Engineers Comments Regarding Surface Water Drainage

Application Reference:	LU/100/26/DOC	Reviewer Reference:	ADC/EXT5/AF
Planning Officer:	Kathryn Welch	Date of Review:	18/06/2026
Site Name:	Ambulance Station East Street Littlehampton BN17 6AU		
Application Description:	Approval of details reserved by condition under LU/45/24/PL relating to conditions 18- Surface Water Drainage Scheme and 19- Maintenance & Management of Surface Water Drainage System.		
Assessment Number:	2

Application Reference: LU/100/26/DOC Site Name: Ambulance Station East Street Littlehampton BN17 6AU	Initial Issue Date: 15/01/2026 Issue Date: 18/06/2026 Reviewer Reference: ADC/EXT5/AF
---	--

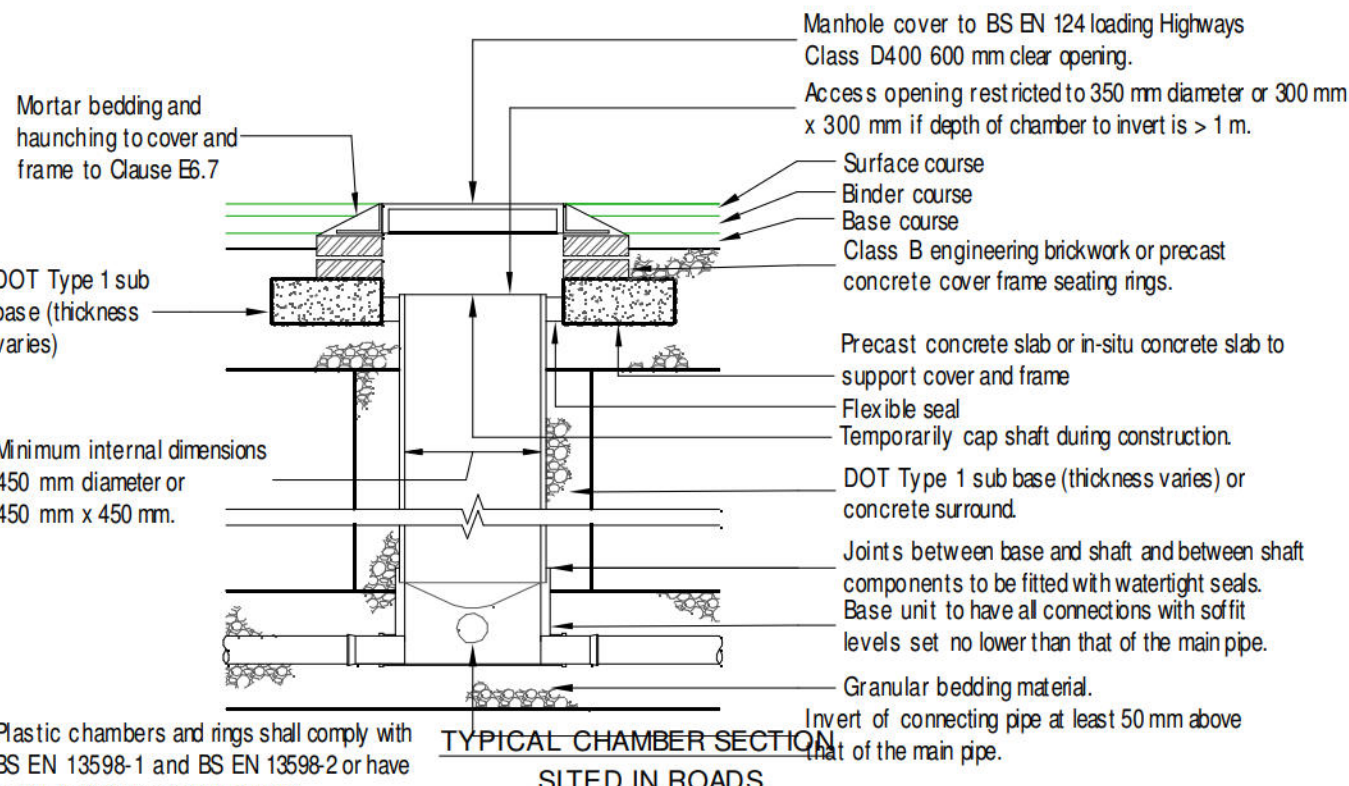
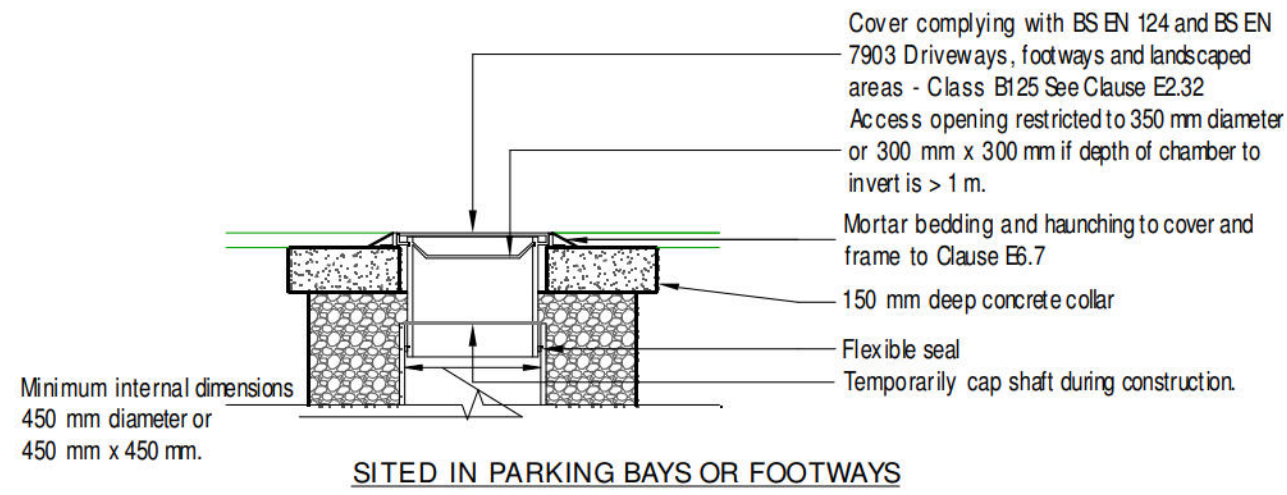
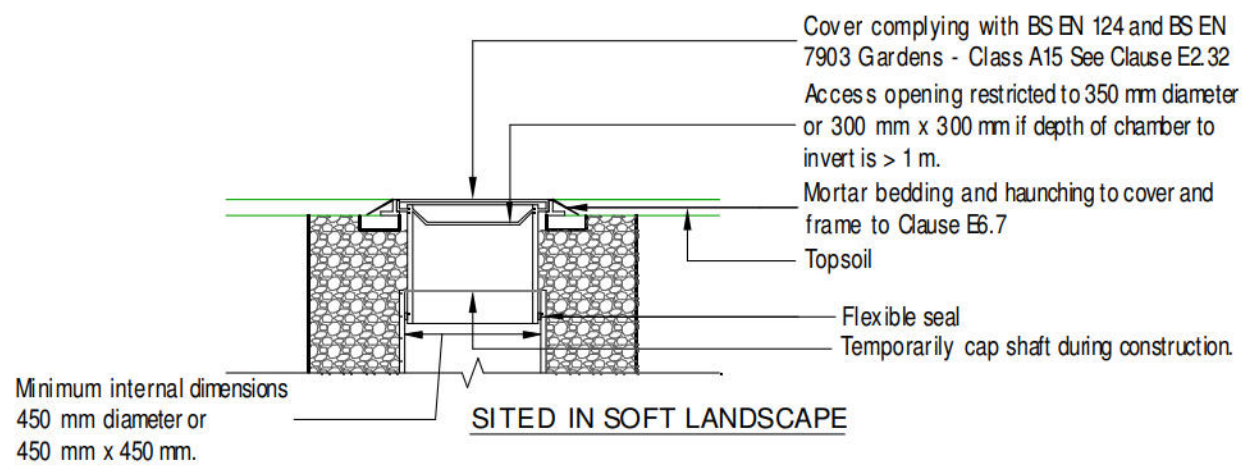
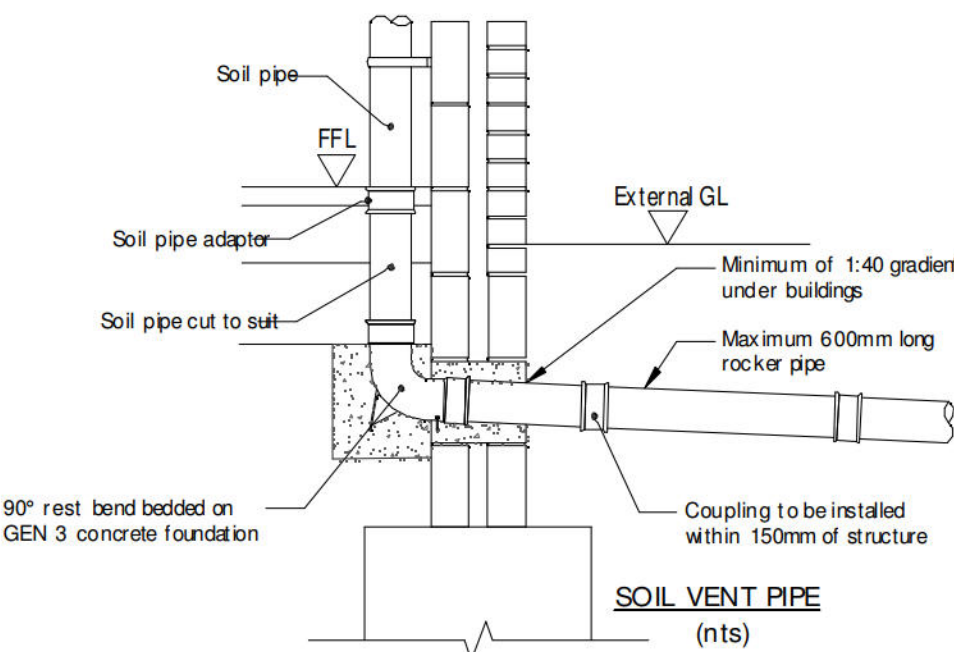
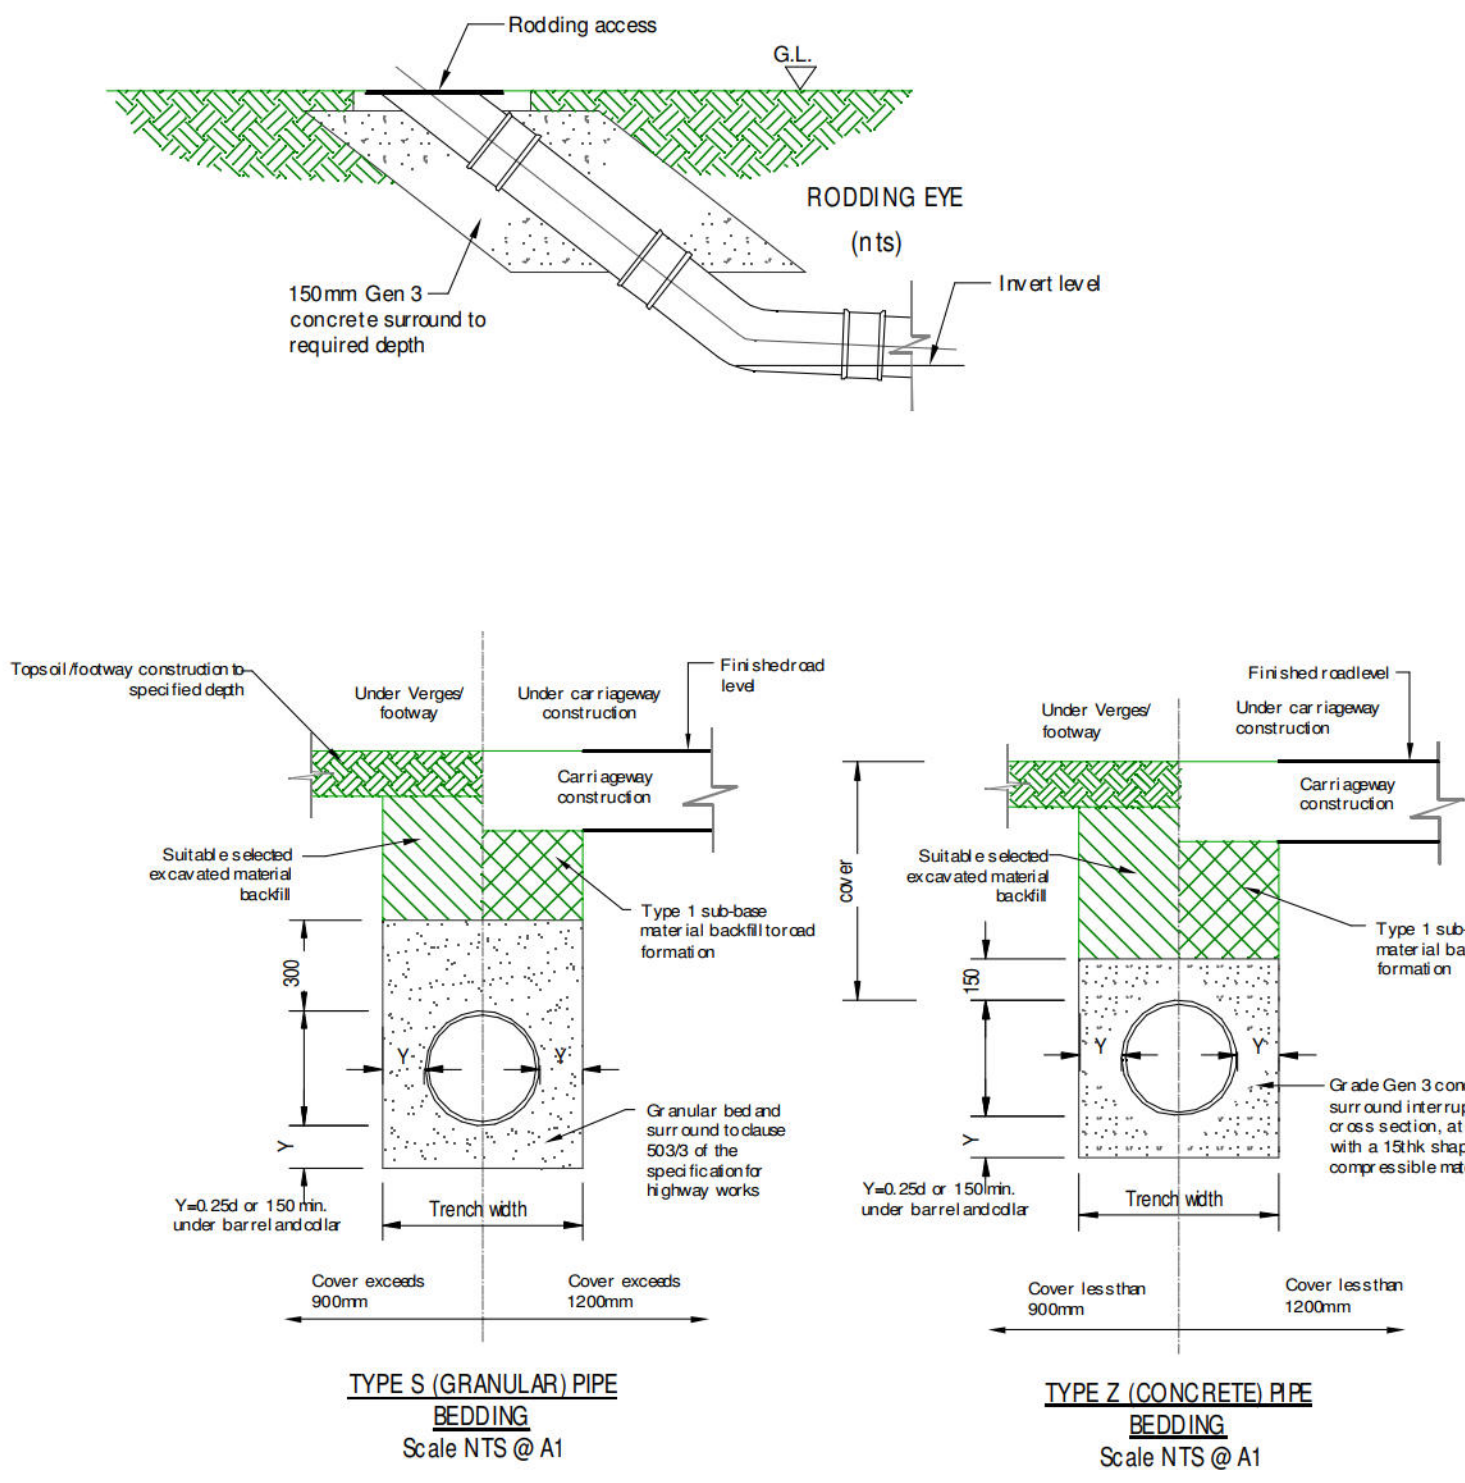
ADC Drainage Comments	ADC Drainage Comments	Designer Response	ADC Drainage Comments	
Date:	15/01/2026 (LU/266/25/DOC)	05/03/2026	26/05/2026	18/06/2026	
Condition Number: 18					
Comment Number					
1.	Confirmation of approval to connect to the combined sewer is required.	Confirmation of approval to connect to the combined sewer is required. ADC Drainage Comments 15/05/2026 Confirmed, comment closed.			
2.	A full technical design should be provided to discharge conditions please provide levels design and details for pavements.	Sufficient detail is now provided. Comment closed.			
3.	The proposed peak flow noted on the drainage plan has increased from the planning stage submission from 0.6l/s to 1.0l/s. Design peak flow should be based upon the per hectare	The flow control has been altered to 0.6l/s. Comment Closed.

5.	The proposed flow control device has a small orifice and could be susceptible to blockage as there are currently upstream inputs not filtered through the permeable paving. The mesh grill is noted and we would also wish to see a high level overflow to prevent flooding in the event of blockage. Consideration should also be given to filtering rainwater from roof areas prior to discharge	The upstream drainage appears to be filtered through sustainable drainage methods but the perforated pipes through the filter drains could convey detritus from downpipes and a risk of blockage to the relatively small flow restriction (35mm) remains. Further clarification of the design to remove the risk of blockage from the flow control device is needed. ADC Drainage Comments 15/05/2026 The design is not clear enough that the connection from the downpipes do not	Silt traps added to downpipes that connect to the perforated pipe. Gravel traps added to downpipes that discharge directly to raingarden surface. S1 and S2 are also silt traps for added protection of flow control chamber. peak flow. The layout plan should also clarify the arrangement as it currently appears to show short lengths of pipe.	Comment closed.

join directly to the perforated collector pipe in the raingardens. A detail is needed to specify the outlet from the rainwater pipes to ensure the flow is filtered as there is no additional blockage protection at the flow control chamber and the restriction is necessarily a very small opening to achieve the desired peak flow. The layout plan should also clarify the arrangement as it currently appears to show short lengths of pipe.

6.	The rain gardens and filter drains included at planning stage are removed and should be reinstated or design changes justified. The roof drainage could also potentially be filtered through the permeable pavement foundation.	Comment closed.

7.	The drainage plan should confirm the base level and any base gradients within the porous attenuation foundation.	Comment closed.			
8.	The technical design should be supported by drainage calculations which analyse the system as a network including pipes, attenuation, flow control and outlet.	Comment closed.
